Our Ref: BN/99/19/HH

**Town & Country Planning Act 1990 (as amended)
Town & Country Planning (Development Management Procedure) (England) Order 2015
Application for Planning Permission for Works or Extension to a Dwelling**

1. Non attached trellis along private drive in keeping with Anglo Dutch garden design
2. Erection of 1 x vehicular gate and 1 x pedestrian gate fronting Church Lane attached to pre-existing oak posts;
3. Planned proposed vehicular gates at both entrances to property fronting Church Lane attached to pre-existing oak posts
4. Planned proposed erection of 2 x vegetal pergolas in front garden to complete Anglo-Dutch garden design

Location Barnham Court Church Lane Barnham

PROJECT:
Barnham Court, Church Lane, Barnham
Elevation of Front Entrance with proposed Gates

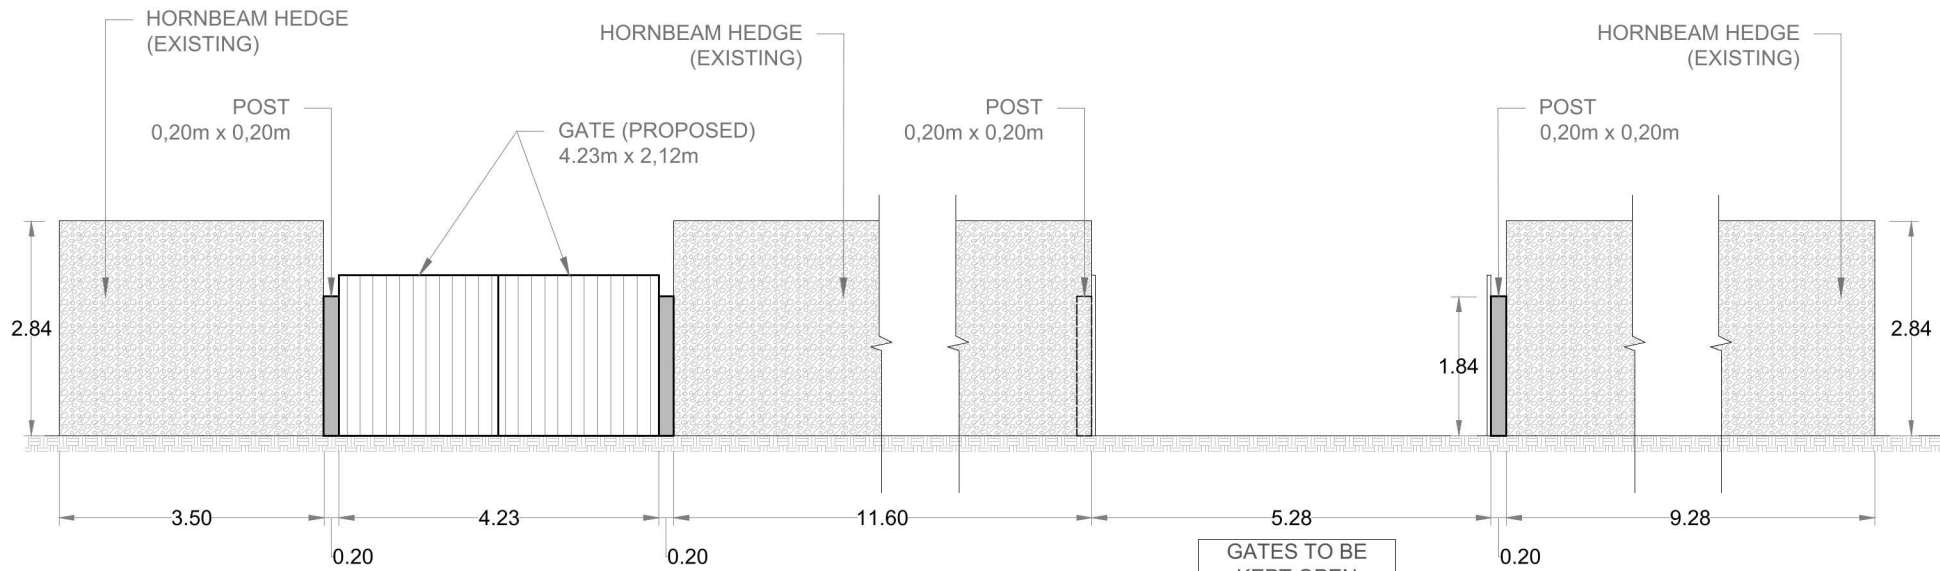
Scale: Your plans are required to be to scale. Please amend.

Elevations required: You are required to provide scaled elevations of the trellis, pergola and gates. Please submit to a standard scale of 1:50 or 1:100.
